Subject: Important update regarding AB/109/20/HH - 32 King Street

Following the conversations had with Mr Moore, I would be willing to agree with the revised plan, subject to the following conditions: -

NORTHERN ELEVATION

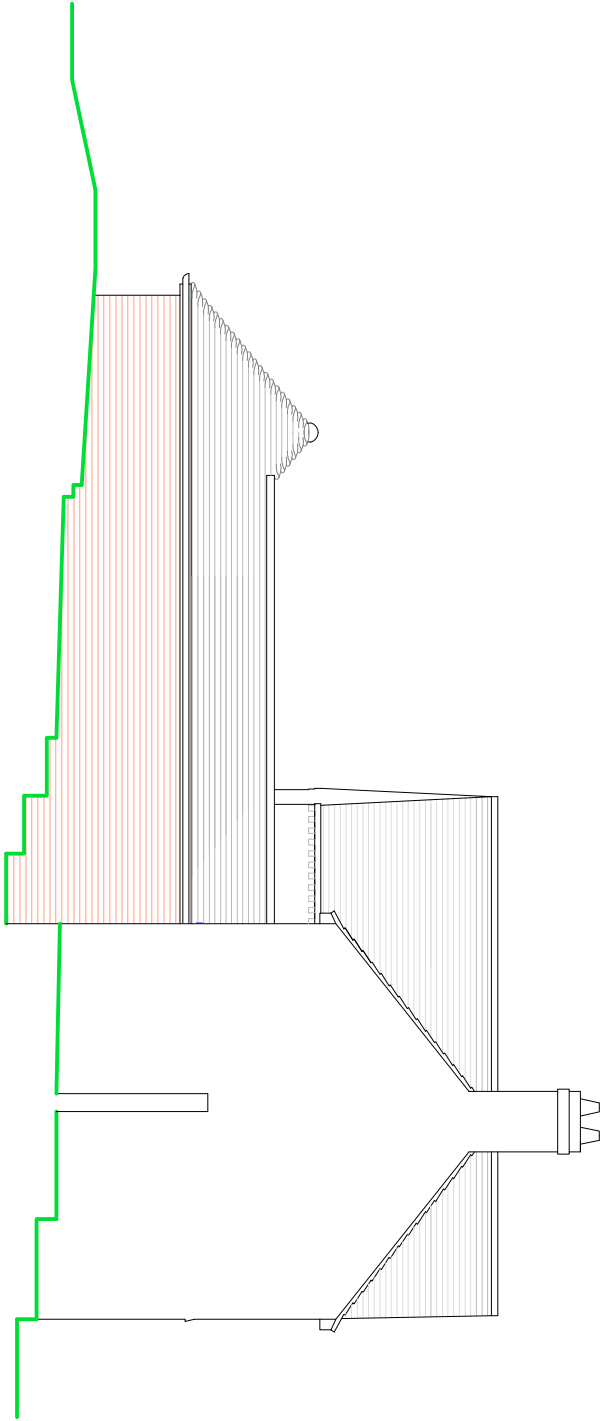
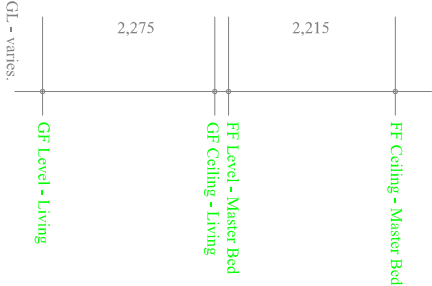
1. The revised position of the north wall of the proposed extension, approximately halfway along the proposed wall, steps away from our shared boundary line, to protect a minimum of 3 meters of beech hedgerow compared to the previous proposed plans. This is far better screening and I very much want to keep as much of the existing hedge as possible. Mr Moore assured me that every provision would be made to protect this section of the hedge during construction, including any barrier 'root' protection.

4. The visible North Wall of the proposed extension, which will not be screened by the hedge, will be faced with traditionally constructed, coursed field flint and lime mortar.
